**RE: JEFFERSON/OSUNA OFFICE BUILDING (E17-D52). ENGINEERS'S  
CERTIFICATION FOR CERTIFICATE OF OCCUPANCY. ENGINEERS  
CERTIFICATION DATED AUGUST 13, 1997.**

**RE: JEFFERSON/OSUNA OFFICE BUILDING (E17-D52). DRAINAGE PLAN FOR  
BUILDING PERMIT APPROVAL. ENGINEER'S STAMP DATED 9-13-96.**

**RE: JEFFERSON/OSUNA OFFICE BUILDING (E17-D52). DRAINAGE PLAN FOR  
BUILDING PERMIT APPROVAL. ENGINEER'S STAMP DATED 8-15-96.**

JEFFERSON / OSUNA OFFICE BUILDING GRADING & DRAINAGE PLAN AUGUST 1996

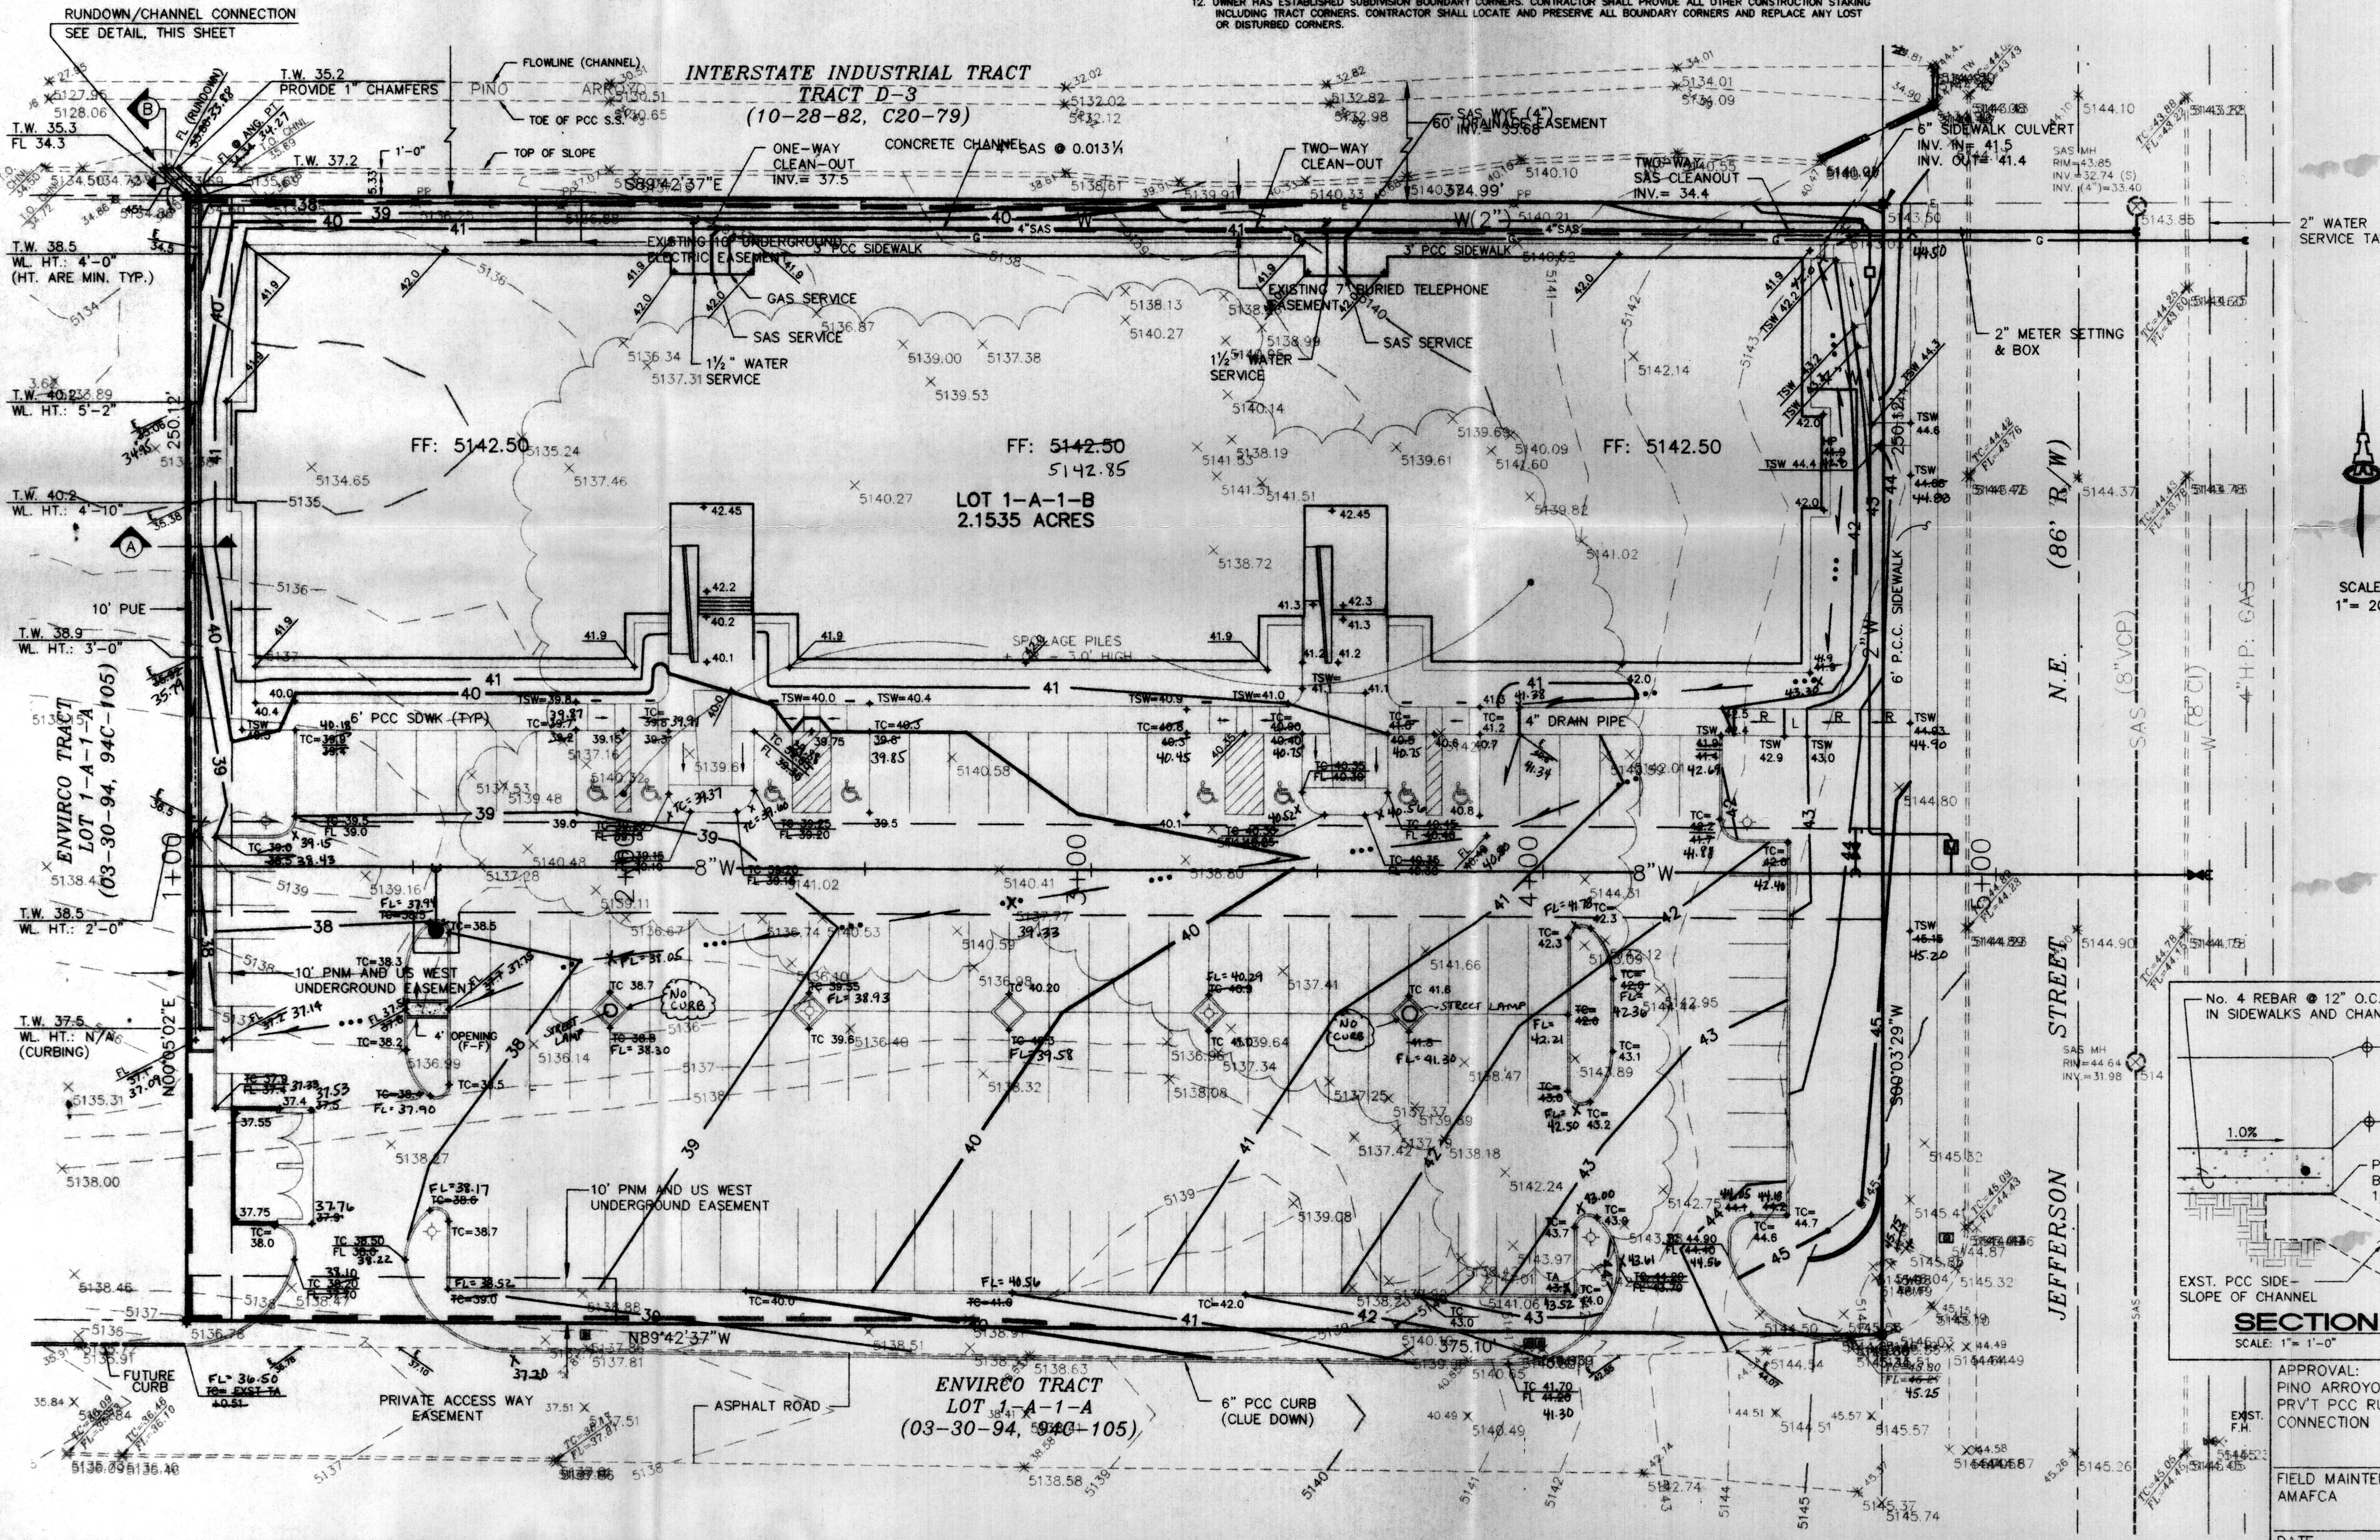
Based on the information provided on your August 19, 1996 submittal, the above referenced project is conditionally approved for Building Permit. Prior to final Building Permit approval, please provide this office with concurrence from AMAFCA. AMAFCA will want to see a channel tie in detail.
